**Application Under Section 96a of the Town and Country Planning Act 1990 (as amended) for a Non-Material Amendment to Planning Permission 22/P/01234**

**AT: Land to the South of New Warren Farm, Warren Farm, Warren Road, Guildford, GU1 2HF**

**FOR: Alterations to External Elevations Including Materials and Fenestrations**

DESIGNER	J Stephensen
PROJECT	LAND TO SOUTH OF NEW WARREN FARM, GUILDFORD
CONTENTS	Granted & Proposed North Elevations
STATUS	Planning
SCALE	1:100 @ A3
DATE	02/10/2023
DRAWN BY	AC
CHECKED BY	A10
APP'D BY	-

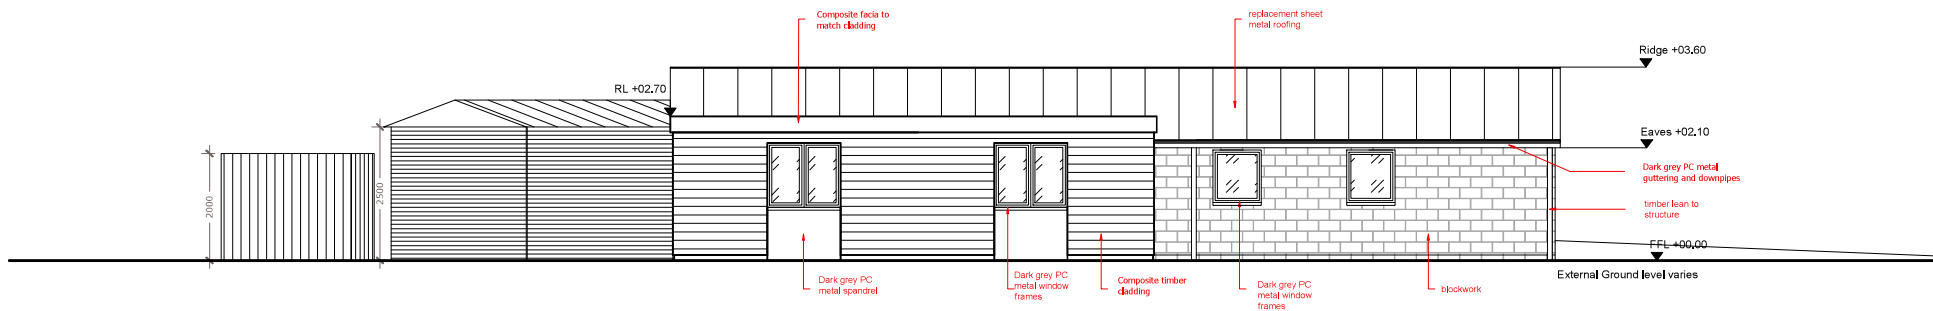
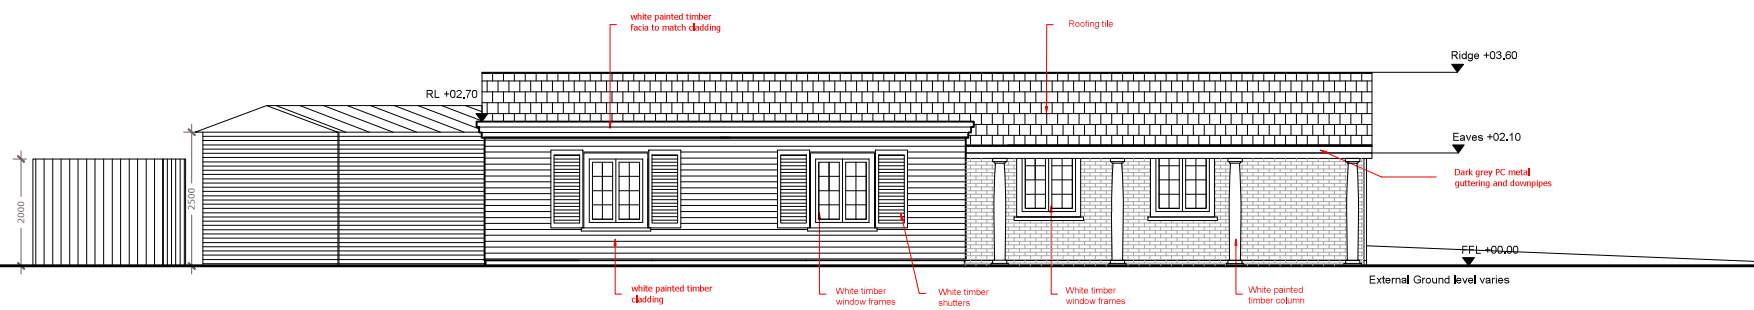
It is proposed to alter the design of all the windows and doors on the building, to provide white timber framed windows with shutters in a traditional style, over the previously approved dark grey metal windows. No alterations would be made to the location of each individual window, nor would the size of the openings be altered. As such, no new windows are proposed and there would be no material change to the impact on overlooking and neighbouring amenity over the approved scheme. Whilst the design would be different, providing a more traditional architectural composition, this would still be of an in-keeping design that would not harm the character of the surrounding area. Therefore, there would be no material impacts on the character and scale of the site and surrounding area as a result of the changes proposed in this NMA over the previously approved design.

It is proposed to alter the materials utilised on the exterior elevations to create a more traditional style of building. Red/brown facing brick is proposed in place of the previously approved block work. Composite timber cladding was approved on the flat roof protrusion, with this NMA seeking approval for white painted timber cladding. Clay effect concrete tiles are proposed on the roof in place of the approved sheet metal roofing. Further, white painted

timber columns are proposed underneath the roof protrusion on the northern elevation, reflecting the traditional style of the proposed building alterations. The proposed changes would create a more traditional style of building over the approved modern materials, however, these would still be considered in-keeping the character of the surrounding area. As such, there would be no material impact on the character of the site and surrounding area as a result of the changes proposed in this NMA over the previously approved design.
